26 May 2009

**TWIN TOWNS SERVICES CLUB EXPANSION
RESPONSE TO DEPARTMENT OF PLANNING TRAFFIC AND PARKING ISSUES**

Reference is made to the Department of Planning's (DOP) summary of submissions and key issues dated 8 April 2009 relevant to the proposed expansions to the Twin Towns Services Club at Tweed Heads.

PROJECT: TWIN TOWNS MAJOR PROJECT APPLICATION stage 2 PROJECT No.: JOB # 335
DRAWING TITLE: PROPOSED PLAN - LEVEL 4 & 5 (Mid Level) DATE: 24.04.09
CLIENT: TWIN TOWNS SERVICES CLUB DA2-10.23 REV. C

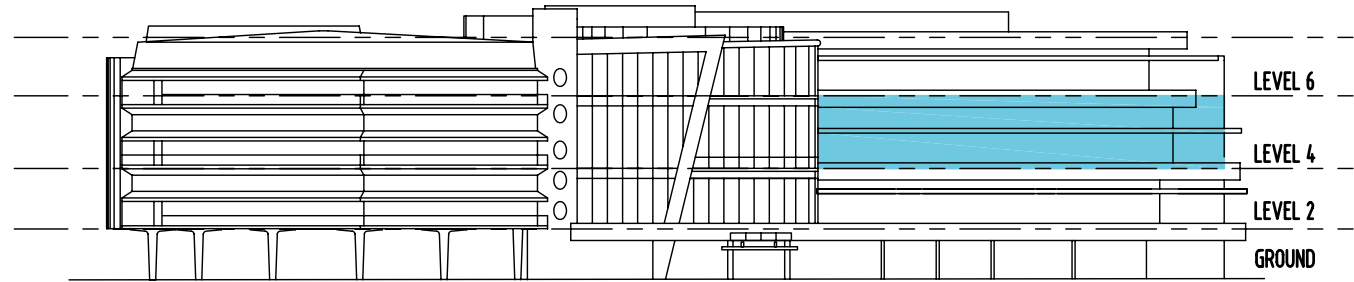
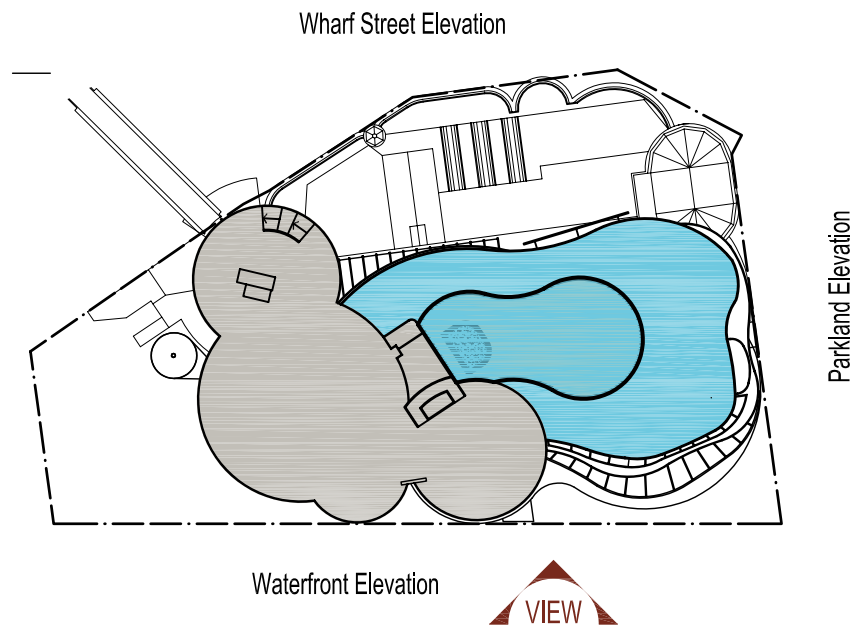
It is confirmed that the cinema/meeting room will have a 280 seat capacity. Drawing DA2-10.23C indicates that the cinema will hold 40 seats per room (80 seats) and the meeting rooms will hold 100 people per room (200 seats).
